May 11, 2022

TIP: U-6202
WBS: 48662.1.1
COUNTY: New Hanover
DESCRIPTION: SR 2048 (Gordon Rd) from US 17 Business (Market St) to I-40

SUBJECT: **Design and Environmental Conflicts**
Parcel #143 Lennon Family Limited Partnership
(Circle K)

CLEARING AND GRUBBING
EROSION CONTROL FOR
CONSTRUCTION SHEET 20

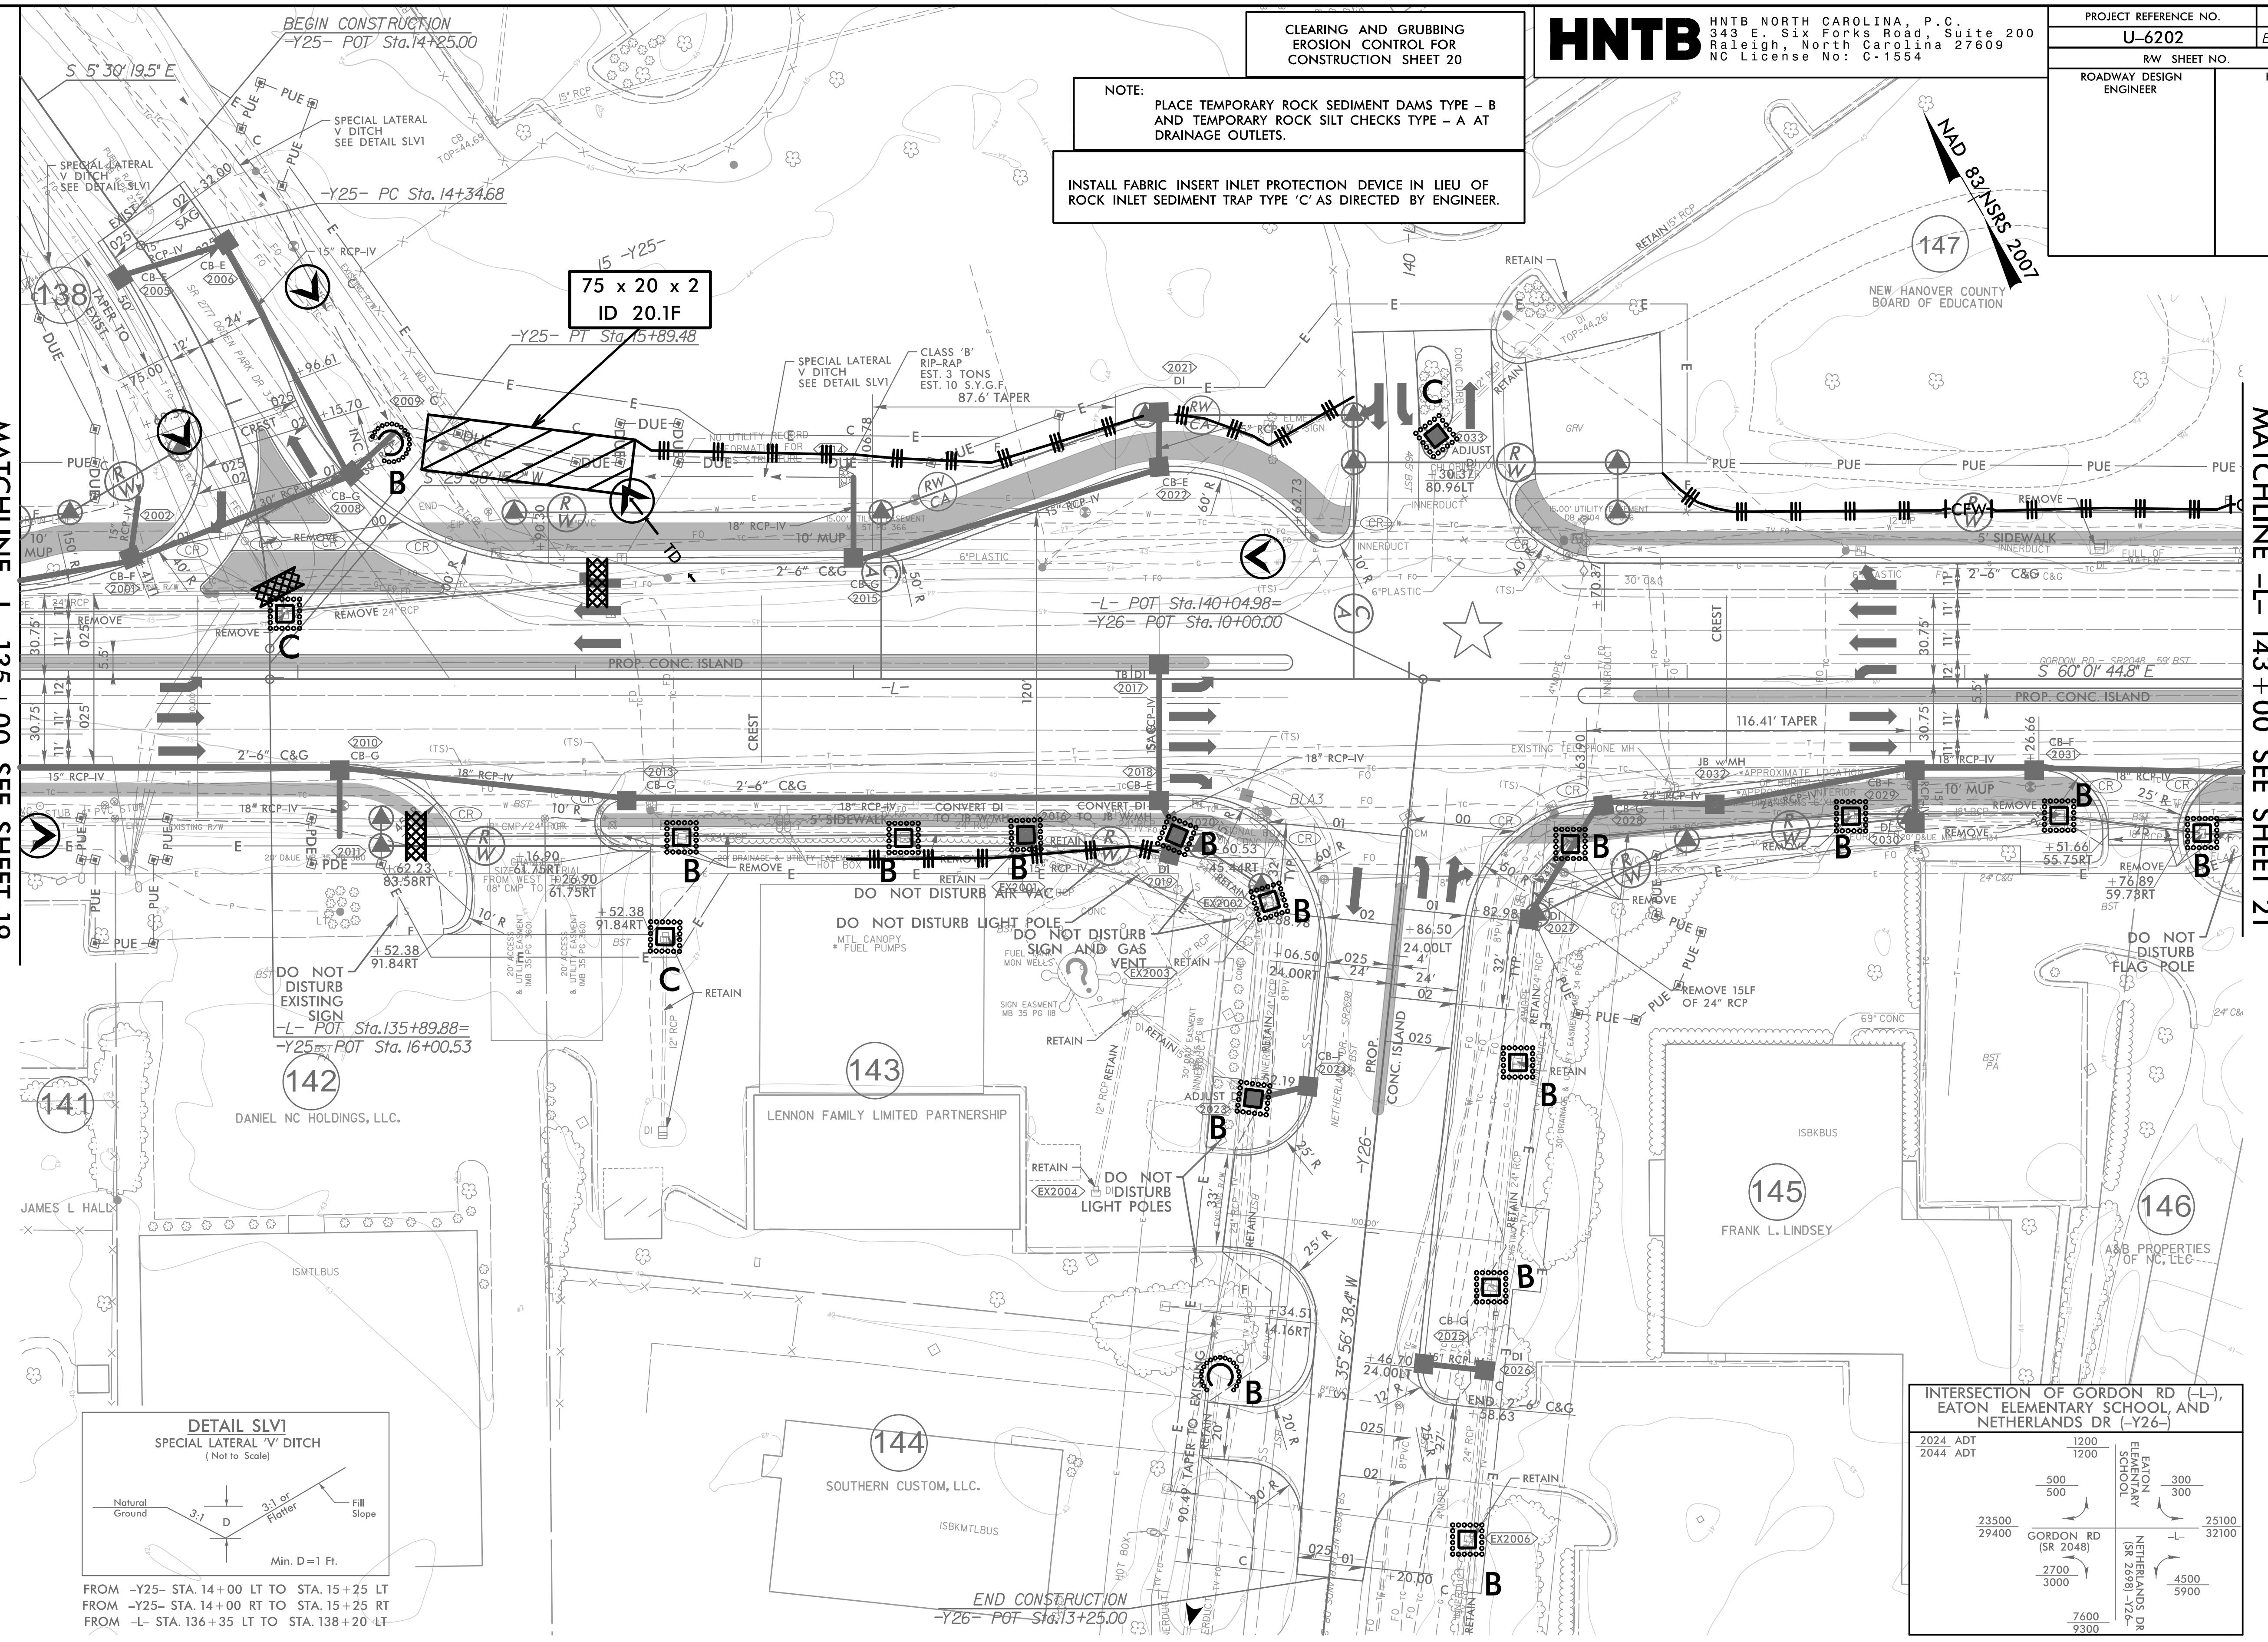
Parcel # 143 is an active gas station/convenience store located on the southwest quadrant of Gordon Rd and Netherlands Dr. The UST vent pipe is located between the proposed right of way and the construction easement. The UST vent pipe should be labeled UST vent. The GeoEnvironmental Section recommends adjusting the construction easement to avoid the UST vent pipe. The fuel canopy and UST pit are just outside the proposed construction. The fuel canopy, UST pit and vent pipe should be labeled **Do Not Disturb**.
